TERRA ASSOCIATES, Inc.

August 5, 2022
Project No. T-8264

Subject: Response to City of Mercer Island Comments
Cheshire Short Plat
7615 East Mercer Way
Mercer Island, Washington

NOTE: INFORMATION SUPPLIED TO GROUND SUPPORT PLLC AT TIME OF SHORING DESIGN INSUFFICIENT TO CHECK FOR ALL POTENTIAL CONFLICTS BETWEEN SHORING ELEMENTS AND UTILITIES. CONTRACTOR IS RESPONSIBLE FOR LOCATION OF ALL UTILITIES WITHIN ZONE OF SHORING ELEMENTS AND FOR CHECKING THAT NO SUCH CONFLICTS EXIST.

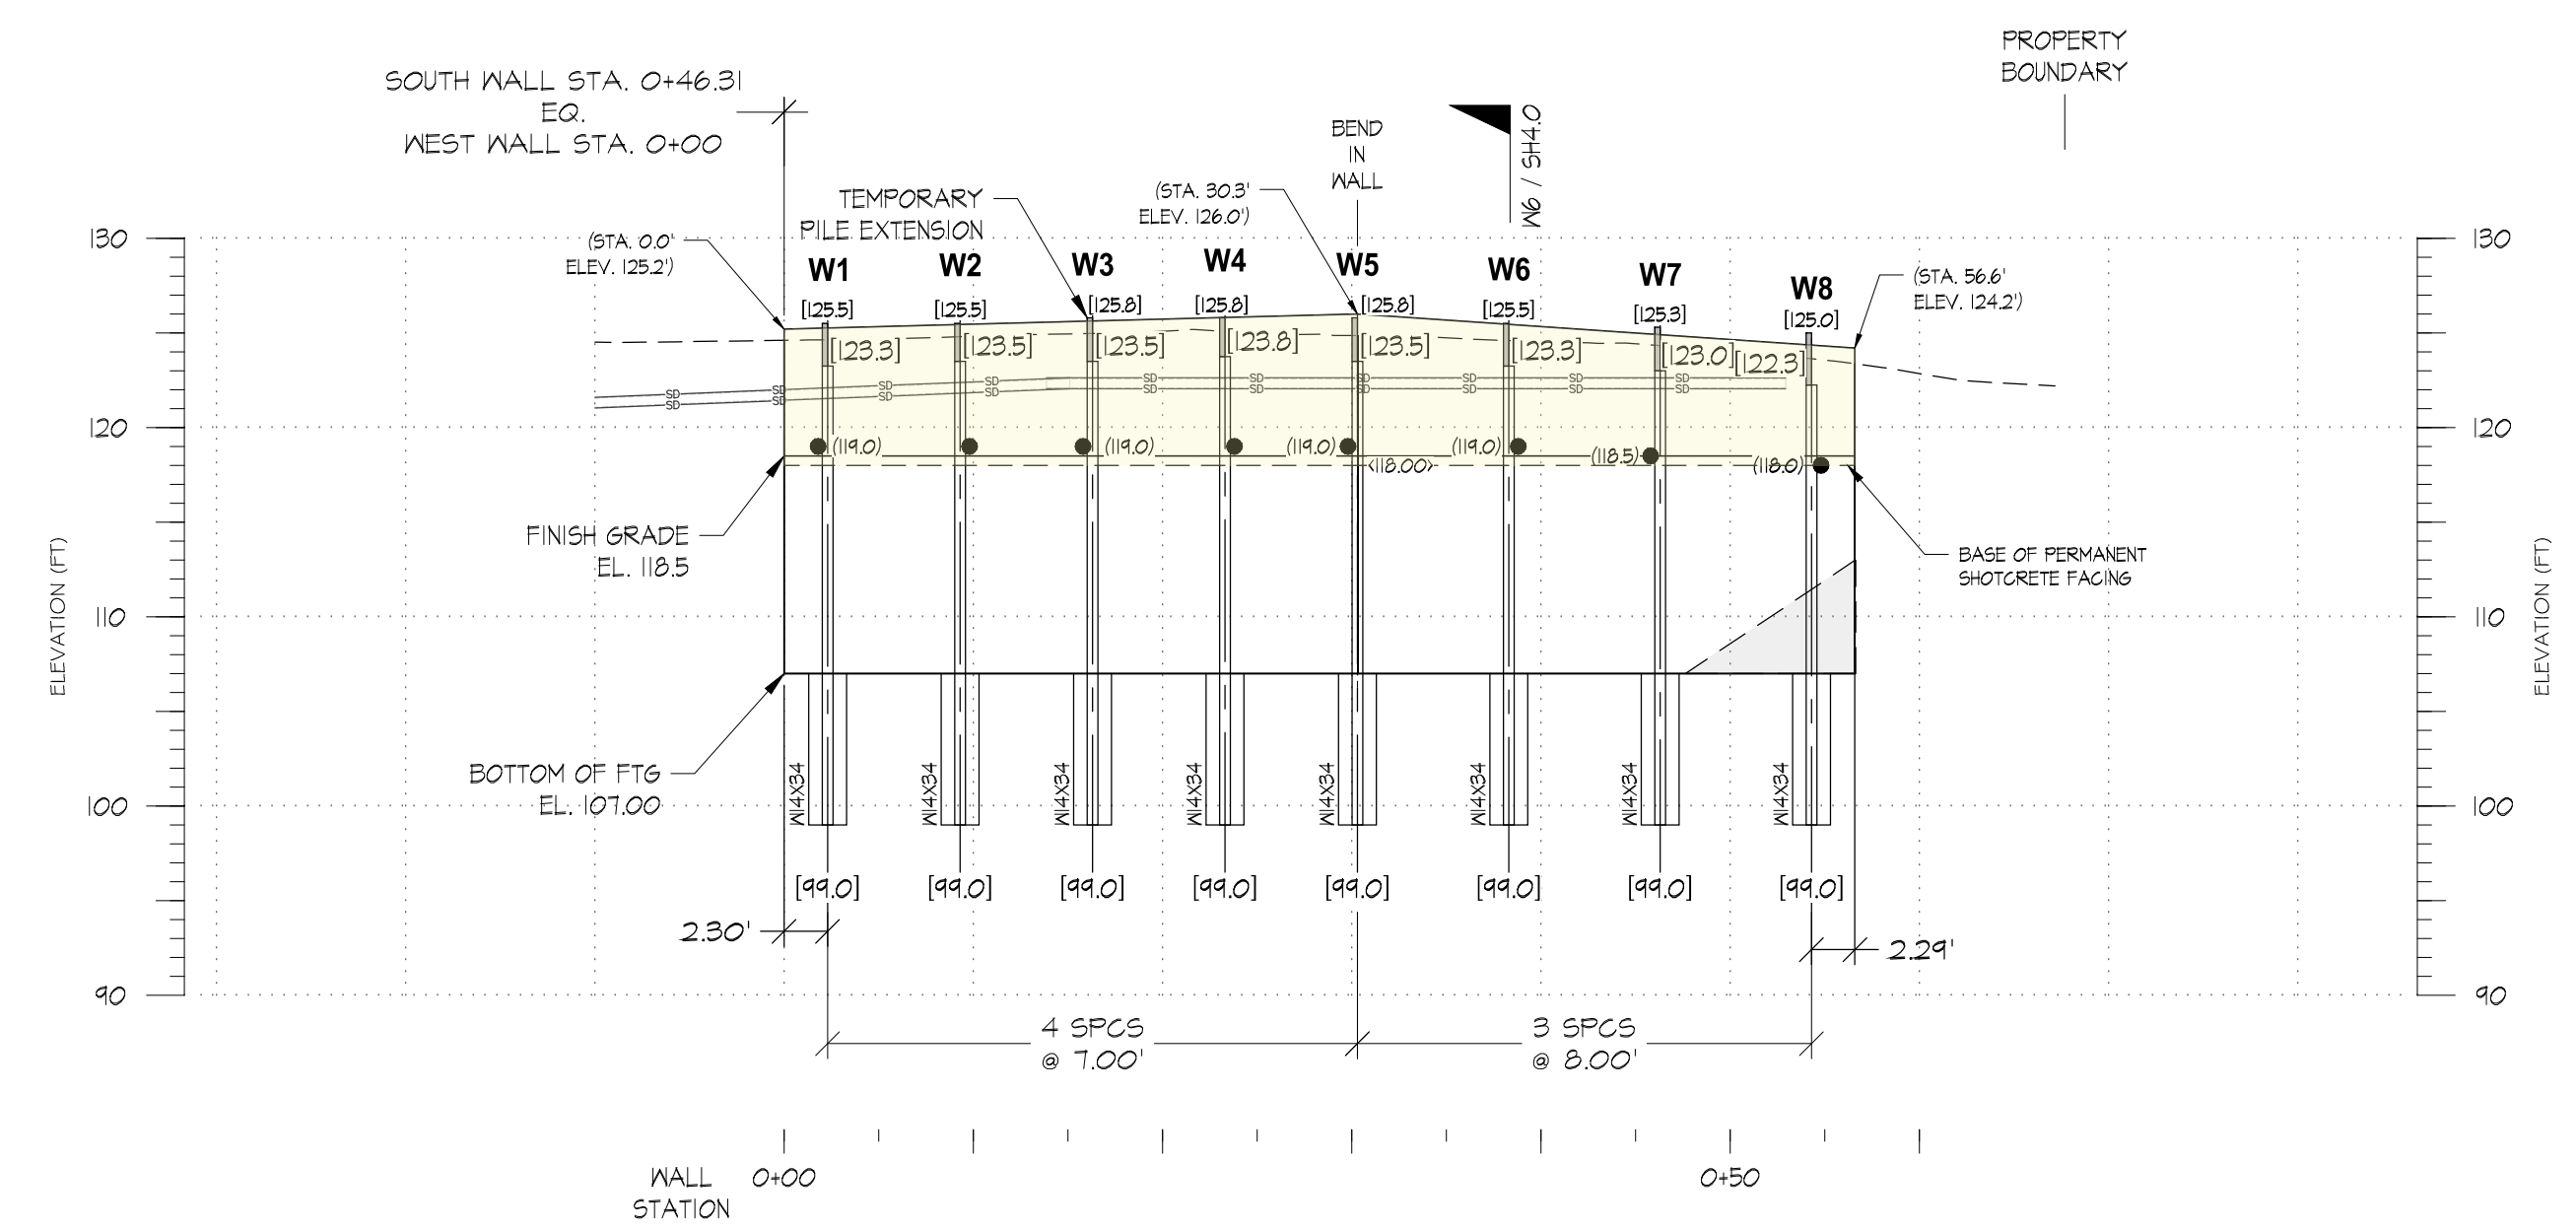
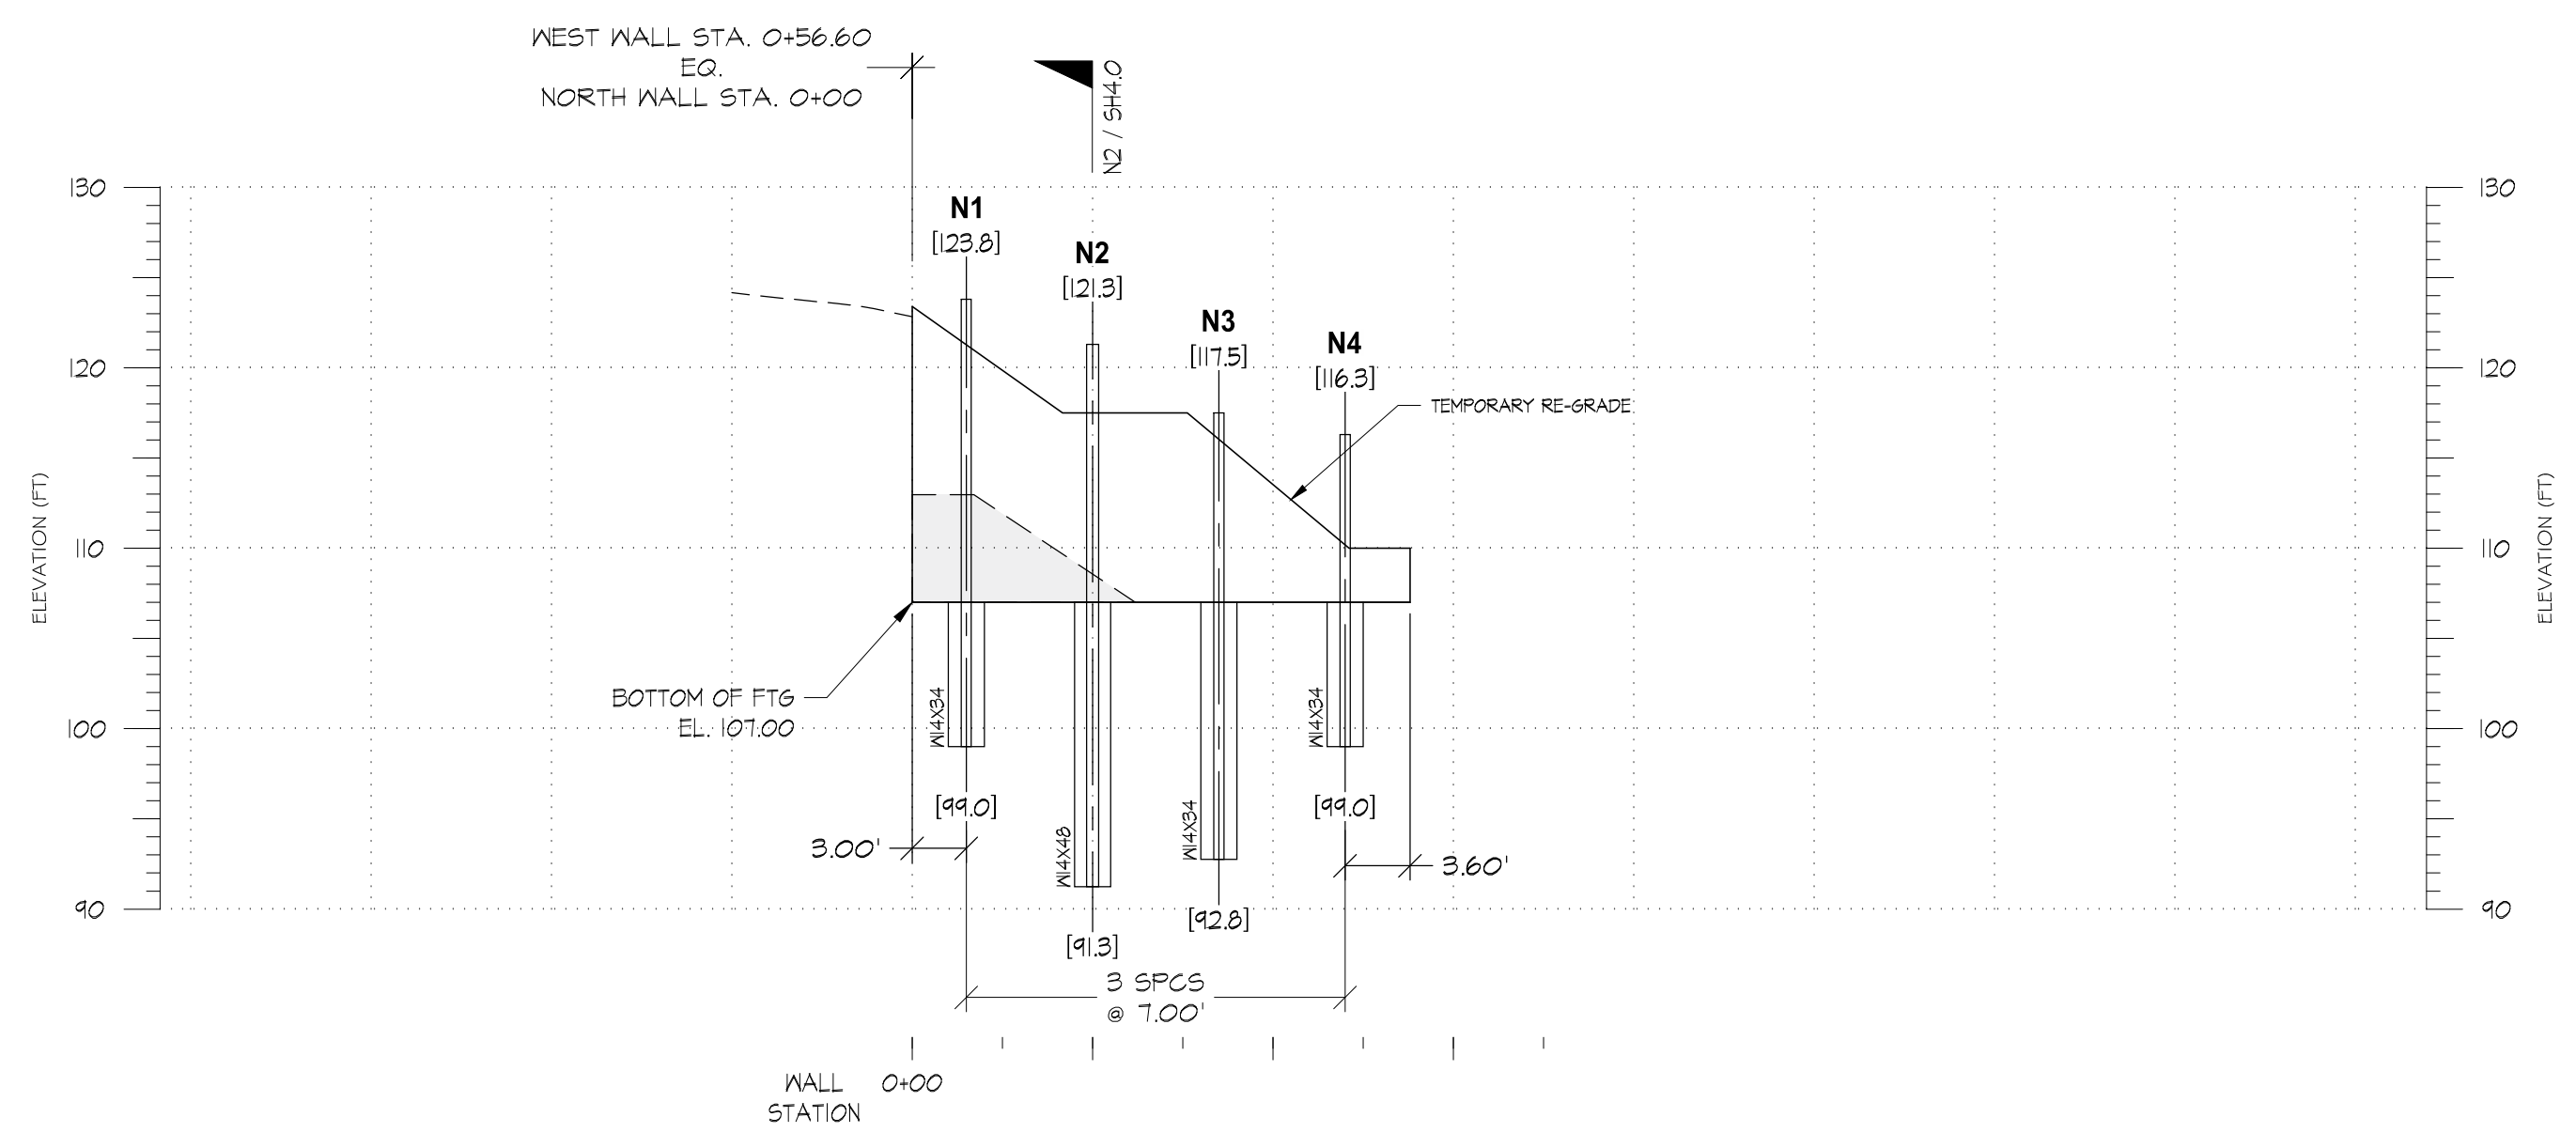
There is also insufficient subsurface information for the location of proposed shoring along the west side of the structure. The type of shoring (ultrablock) requires an open cut. Will the open cut be stable to allow installation of the ultrablock without undermining utilities upslope? Is there enough space to install ultrablock? An alternate shoring system or temporary construction easement from the uphill property owner should be considered if these issues cannot be resolved.

If an open cut is proposed, slope stability analyses of the temporary cut will be required. Geotechnical engineer should include discussion on potential undermining or relocation of existing utilities upslope given the results of the stability analyses.

Provide location and extent of proposed shoring including top and bottom shoring wall elevations. Provide detailed shoring design and calculations for review.

We respectfully disagree that there is insufficient subsurface information to analysis the use of Ultrablock Shoring for the proposed excavation. The referenced geotechnical engineering addendum outlines the assumptions used to determine the system is viable on a temporary basis. Yes, a temporary open cut is required to install the Ultrablock shoring, however, as noted on the wall details, the excavation for the wall should be completed so that exposed soils are completed covered at the end of the workday thus reducing the potential impact from an open and unsupported excavation.

The location of the proposed shoring is shown on the design plans. The shoring design and calculations are in the referenced geotechnical engineering addendum.
